Re : Land at Stakers Farm, Yapton – Y/71/20/RES

Further to the e-mail of the 15th September 2020 containing drainage queries we would like to provide additional information to address these.

Job Title			
LAND AT STAKERS FARM, YAPTON			
Drawing Title			
HIGHWAY CONSTRUCTION DETAILS (SHEET 1 OF 2)			
Client			
DANDARA LIMITED (SOUTHERN)			
Scale	Date	Designed	
AS SHOWN @A1	SEP 2020	AK	
Drawn	Checked	Approved	
JK	AK	SW	
Job No	Drawing No	Rev	
19-156	YAP-180-035	T2

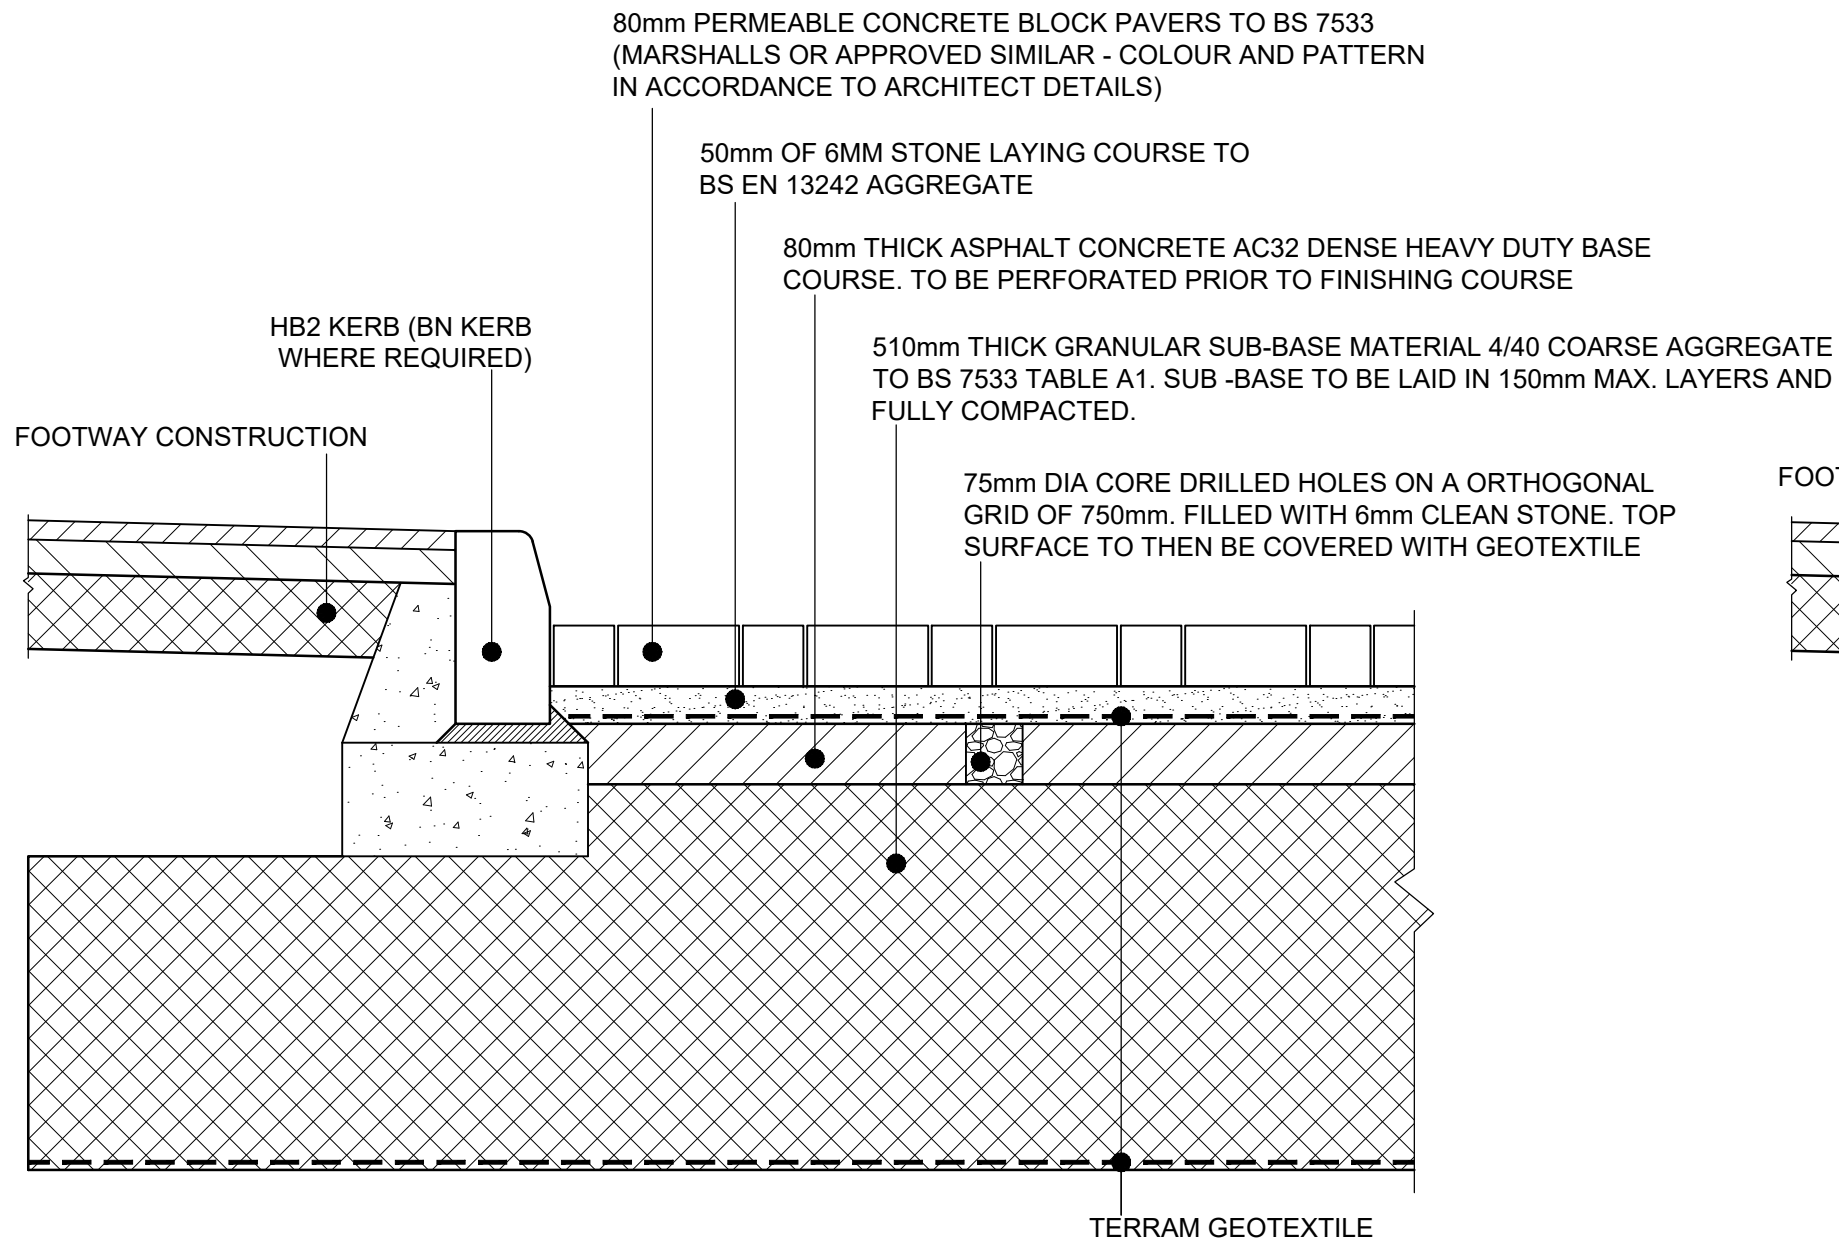
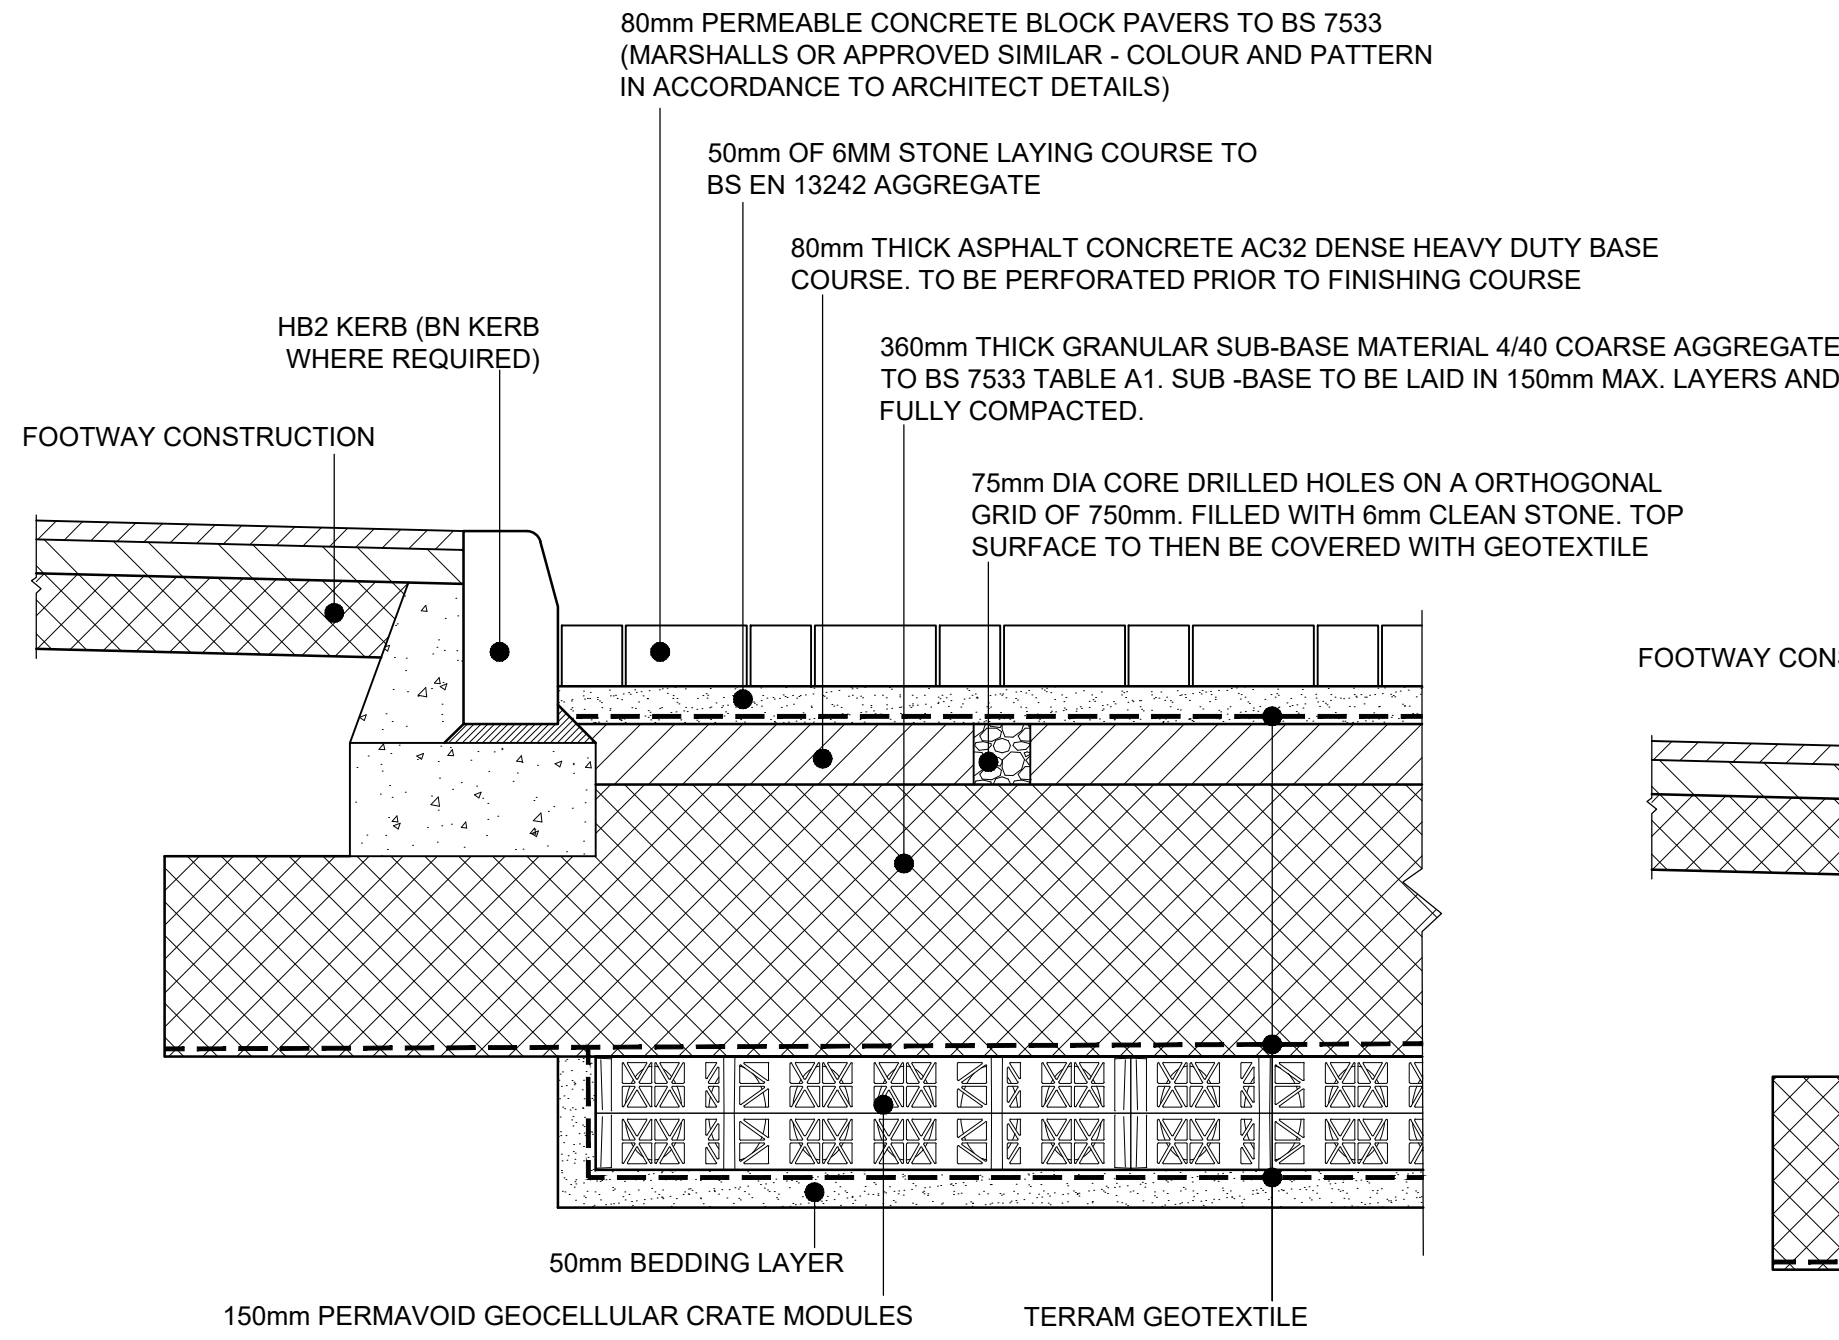
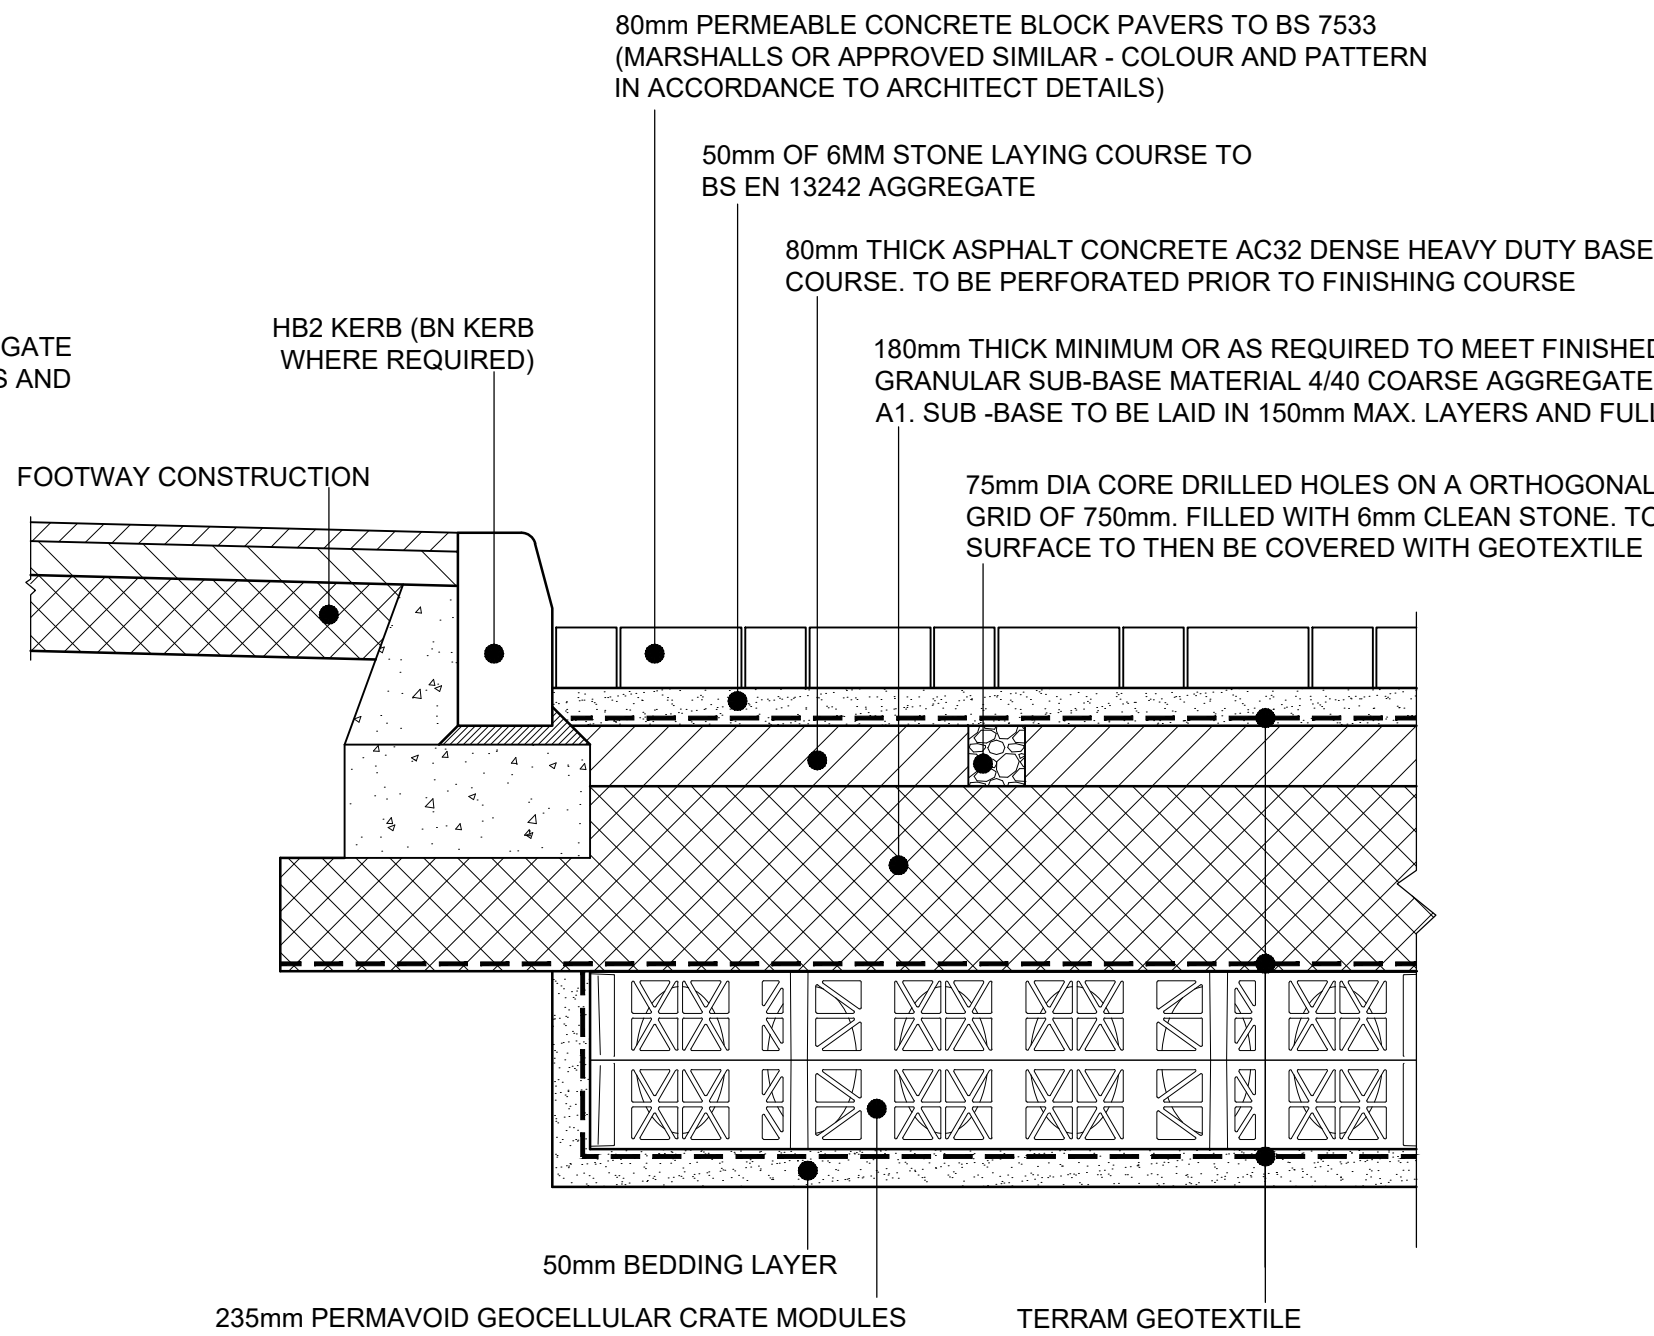
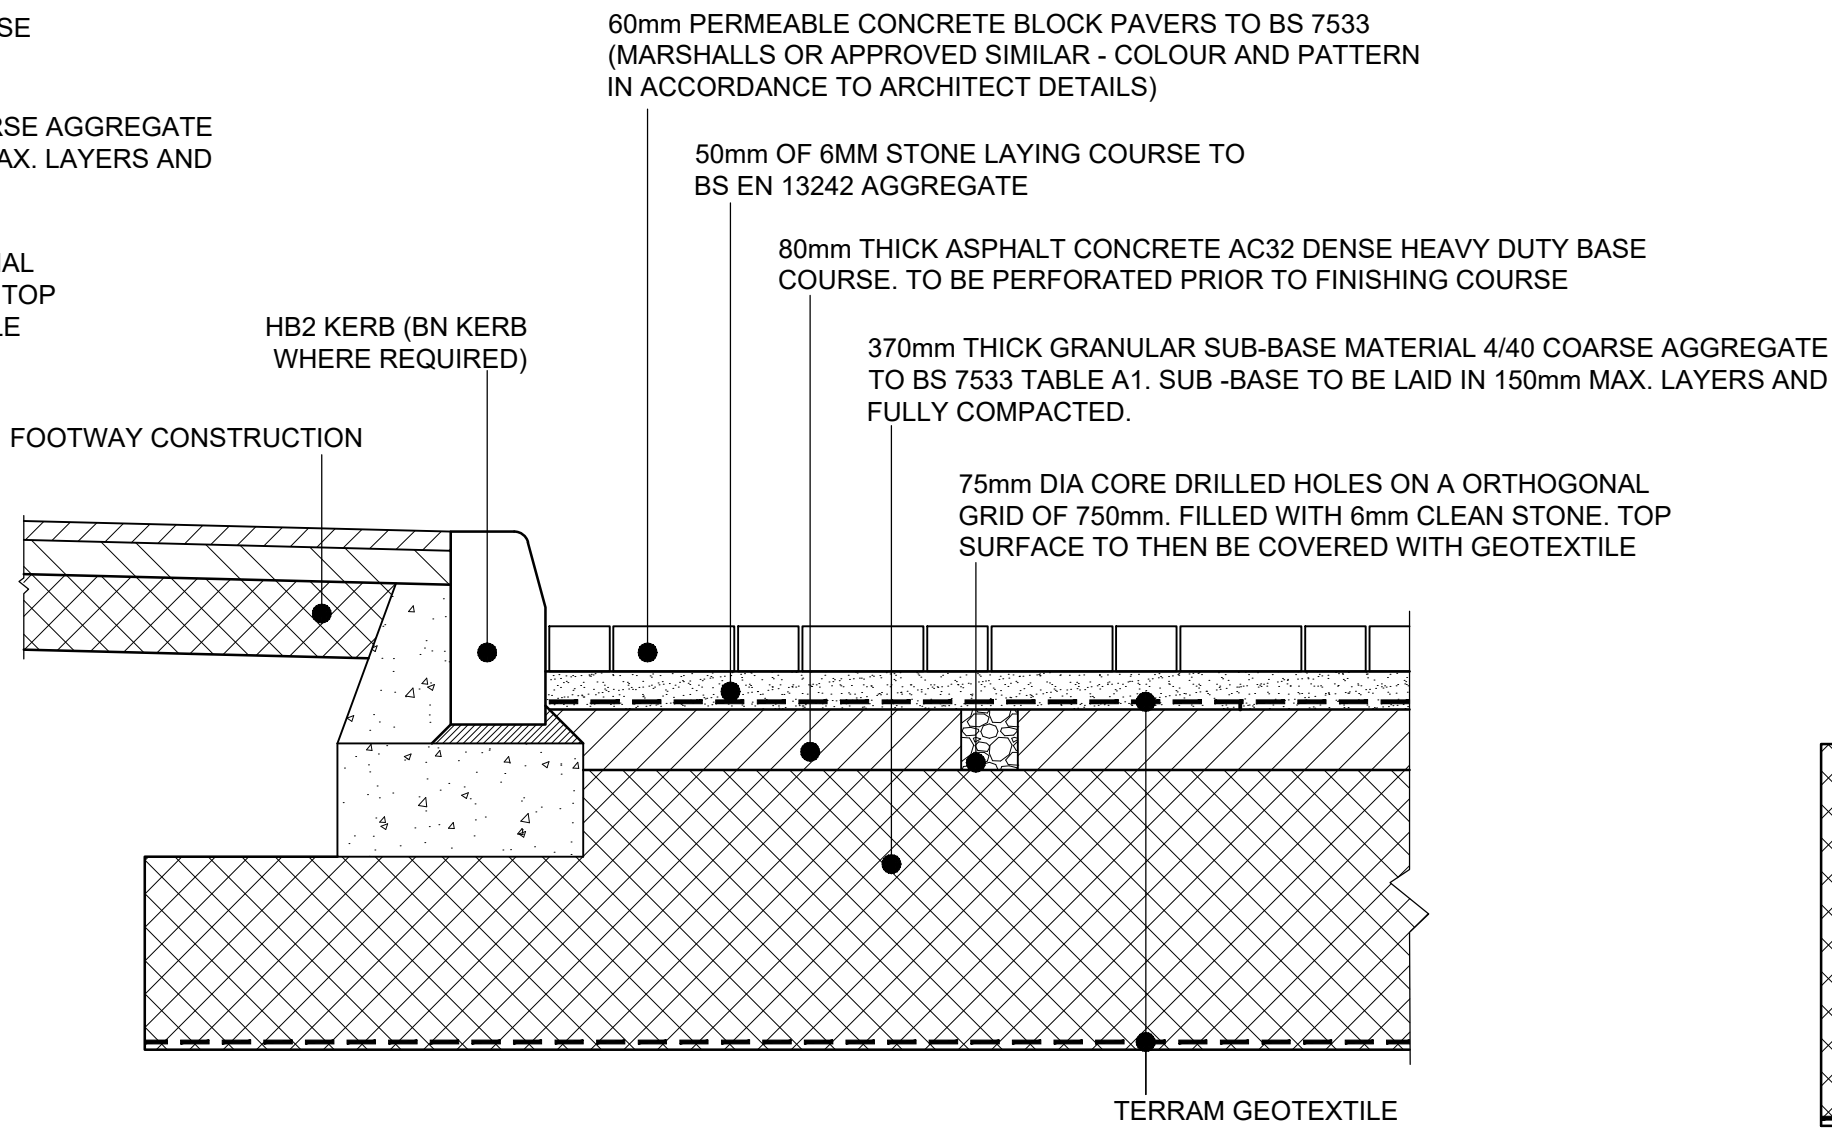
3. *"Please provide construction detail drawings of pipe bed and surround"* – Please refer to drawing YAP-180-31A.
4. *"Please provide construction detail drawings that clearly correspond to each of the proposed permeable paving types"* - Please refer to drawing YAP-180-35.
